RE: SSD 7603; Nos. 24-28 John Street and Nos. 4, 6, 8, 10, 12, 14, 16, 18, 20, 22, 24, 26 and 28 Board Street, Nos. 3, 5, 7, 11, 13, 15 and 17 Ann Street, Lidcombe 2141 NSW

I object to part of the abovementioned proposal, namely the above-ground multistorey carpark that will be constructed on Board and Ann Street. I have not included any objection to the proposed hotel in this submission. Internet hyperlinks have been included for your convenience.

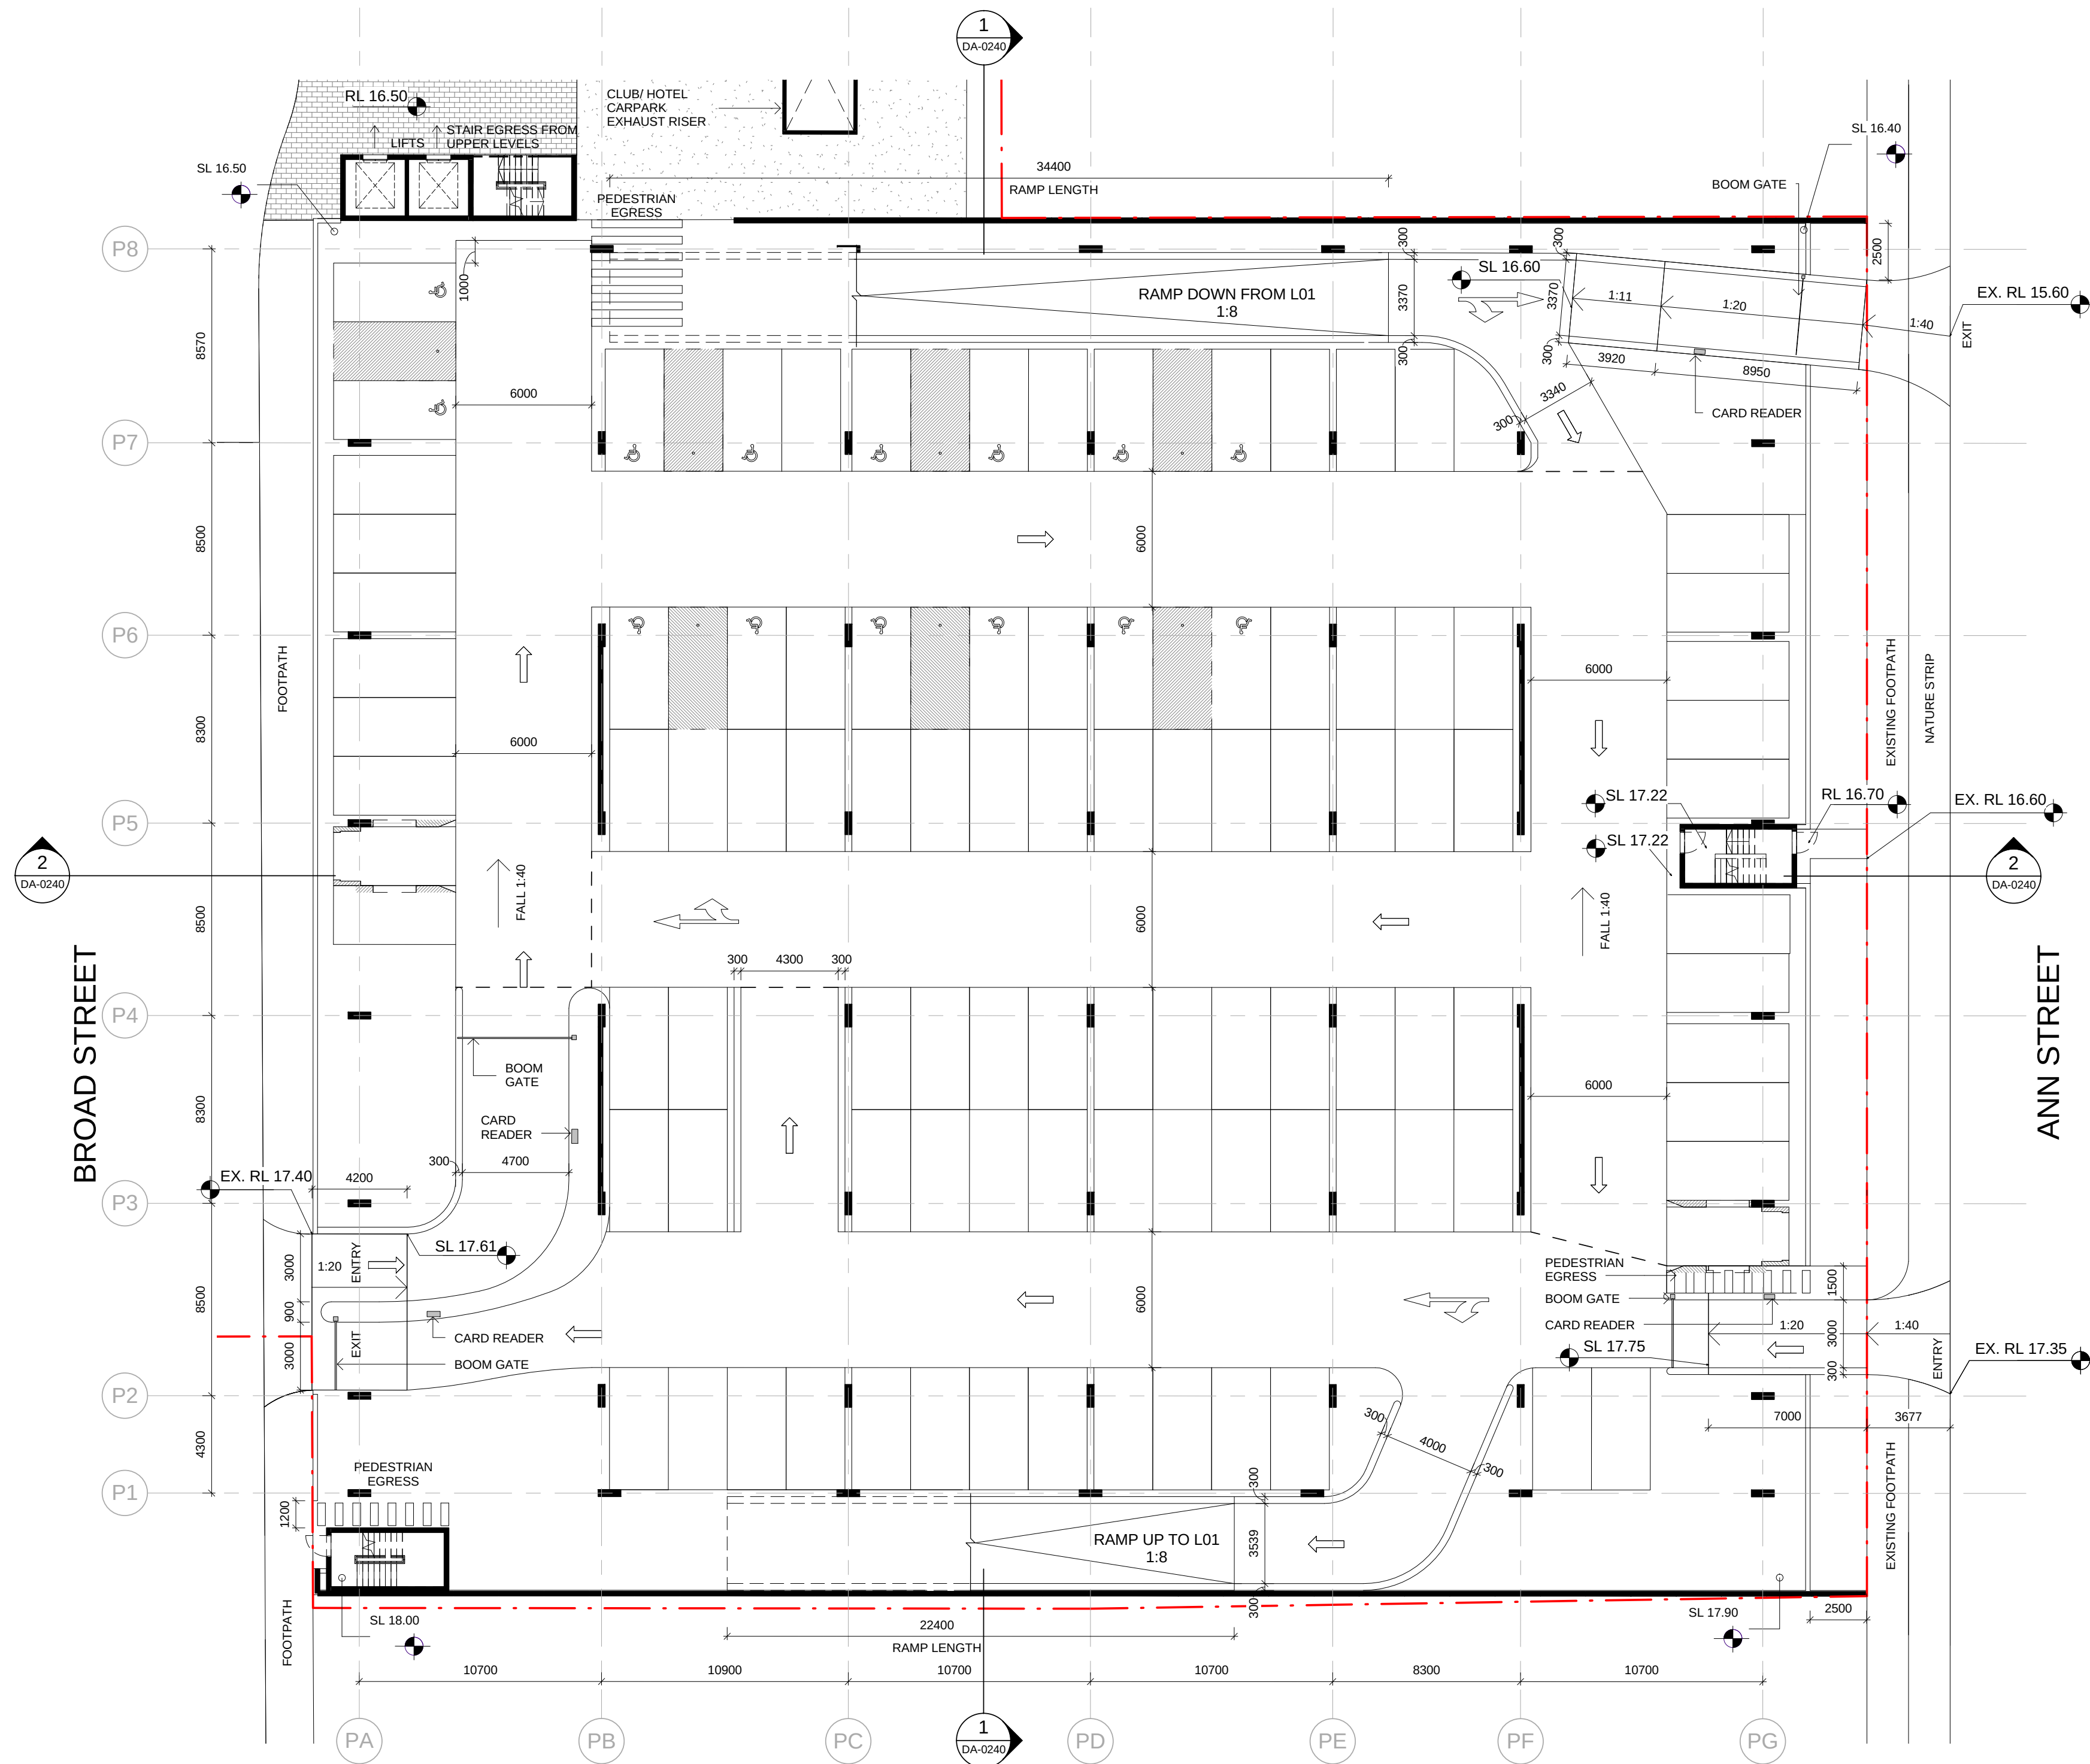
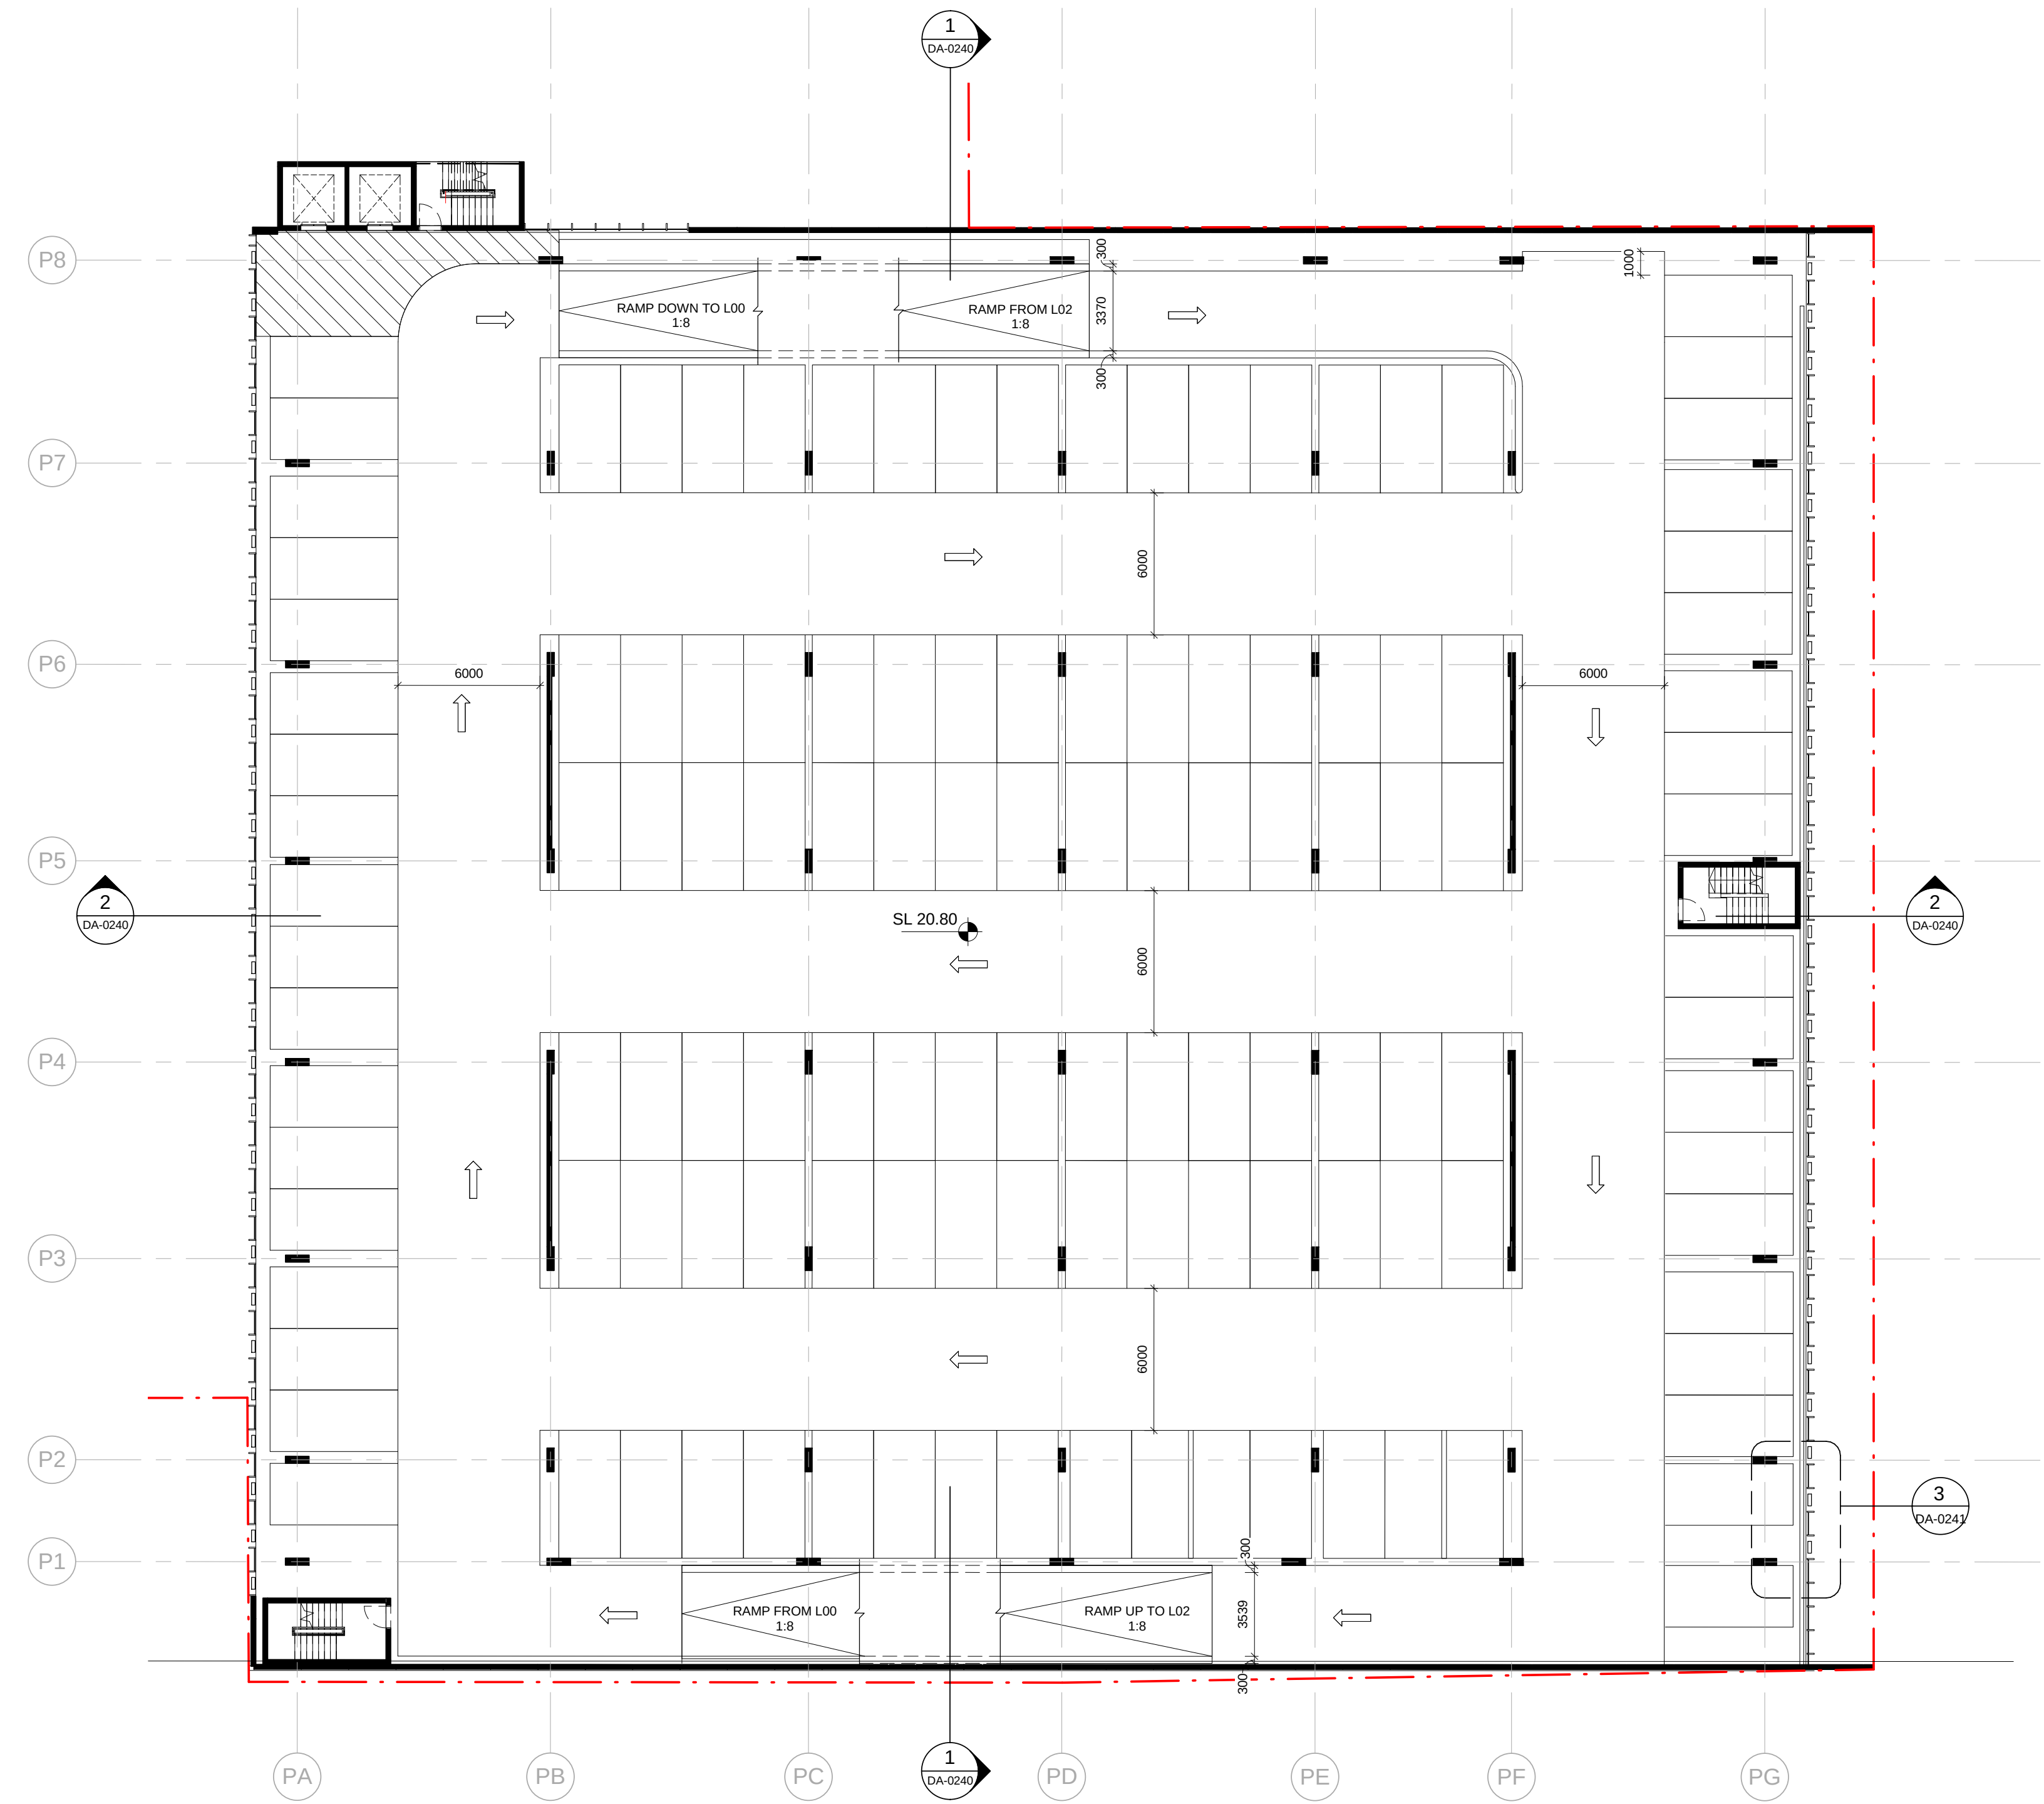
C 1 Overshadowing and reduced access to amenity - with the construction and operation of the proposed carpark on Board and Ann Street there will be dramatic overshadowing and reduction in solar access affecting my property. My property is already adjacent to the previously approved multistorey development at 36 – 44 John Street (currently under construction as of writing), which already has a significant overshadowing effect on my property. It is only logical to consider the cumulative impact of the proposed carpark (to the west) and the existing multistorey development (to the east) on my property.

The proposed carpark will decrease my solar access from current levels to a much smaller window of time. Currently, with the existing multistorey development on my eastern boundary, on the winter solstice (June 21), my property receives a little under five hours of uninterrupted access to sunlight in private open space between 9 – 3pm in good weather. With this proposed carpark, the loss of solar amenity would be exacerbated and solar access reduced to less than 3 hours. This will be further explained in **Appendix A**.

C 2 Residential Interface - the proposed carpark will be built much too close to my western boundary. My property would then be closely flanked on both my western and eastern boundaries by multistorey developments.

- I 1** Instead of building so close to the boundary, setback the proposed multilevel carpark **at least 3 metres** from our common boundary.
- I 2** Instead of the current design with no stepping down, change the design of the carpark such that there is a **step-down**, with the higher storeys being closer to Olympic Drive than those closer to my property. In Figure 1, I have shown a situation where I would increase my solar access. The eastern wall of the first storey could be spaced at least 10 – 12 metres from the eastern wall of the second storey. The eastern wall of the second storey could be spaced at least 10 – 12 metres from the eastern wall of the remainder of the storeys.
